# KITTITAS COUNTY

### MEMORANDUM

**TO:** All Staff  
**FROM:** Public Works Plan Review Team  
**DATE:** December 22, 2023  
**SUBJECT:** SP-23-00011 Barker

BARKER SHORT PLAT  
PART OF SECTION 6, T. 17 N., R. 20 E., W.M.  
KITITAS COUNTY, WASHINGTON

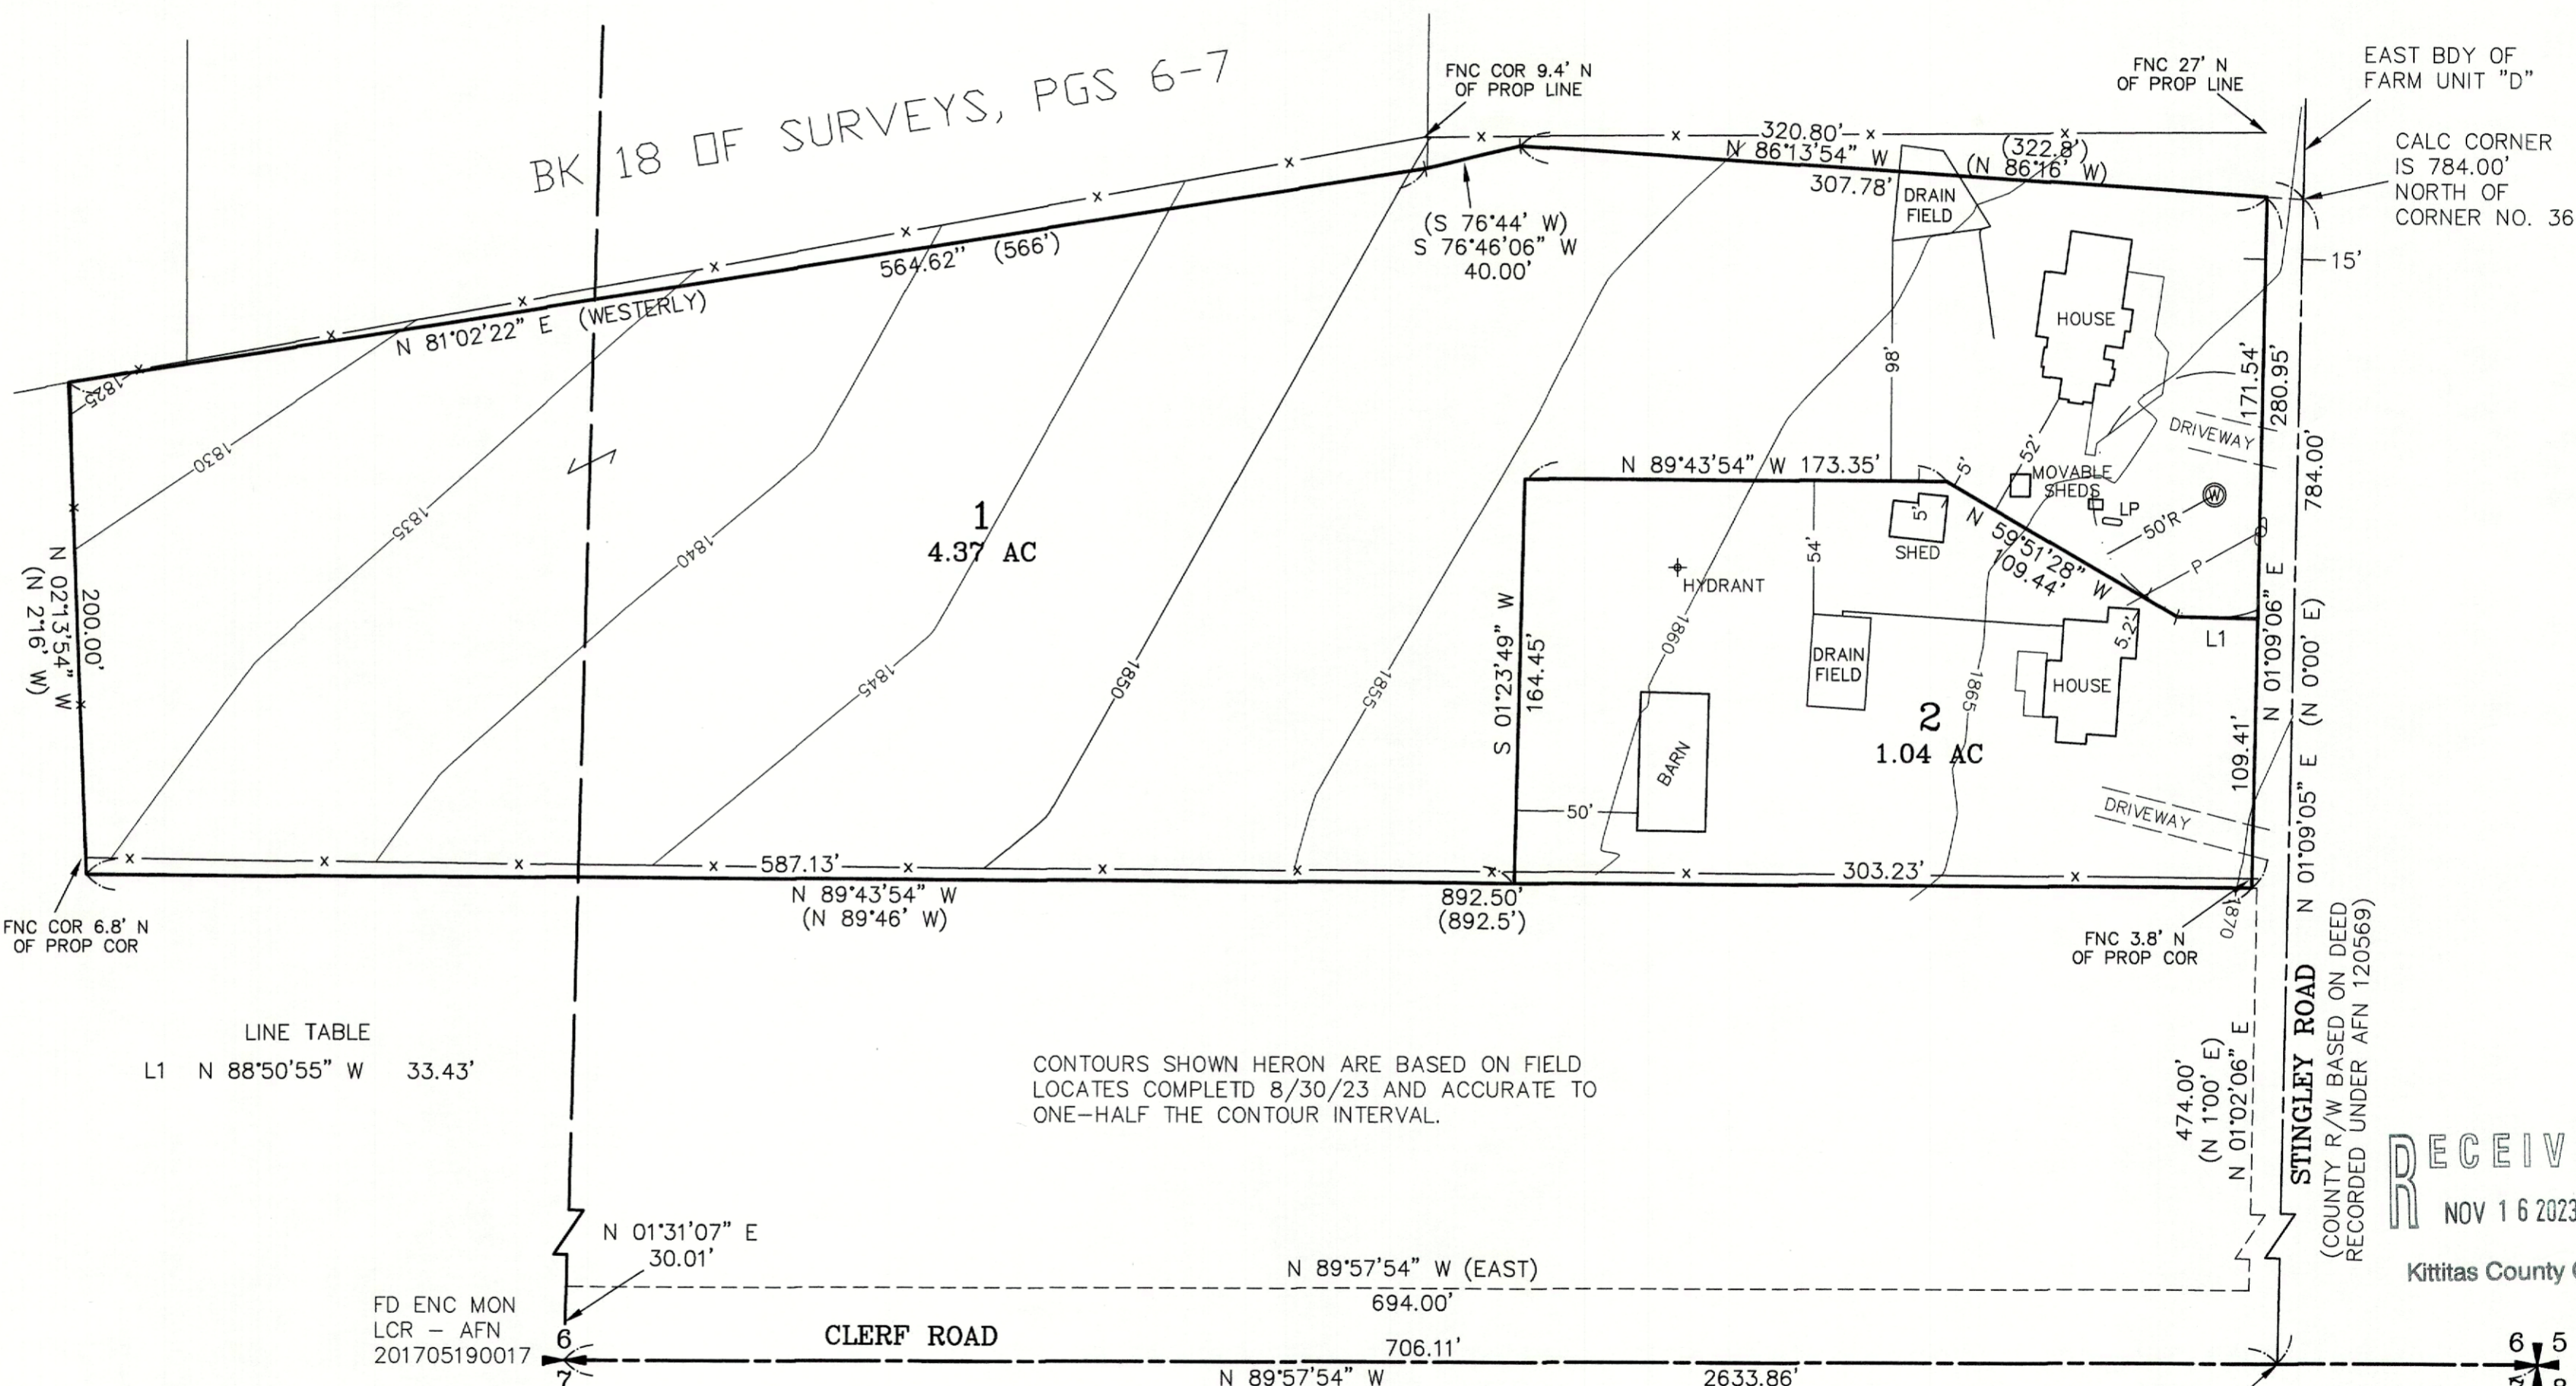
<b>SURVEY</b>	Application does not meet the requirements of WAC:332-130-145. (JT)
<b>TRANSPORTATION CONCURRENCY</b>	No Transportation Concurrency Comments. (TM)
<b>FLOOD</b>	Parcel # 890533 is not located in the FEMA identified special flood hazard area (100-year floodplain). (SC)
<b>WATER MITIGATION/ METERING</b>	Water mitigation and metering standards in KCC 13.35.027 for plat approval are satisfied since the houses share an existing exempt well and the proposed project does not include a new use of groundwater. (SC)
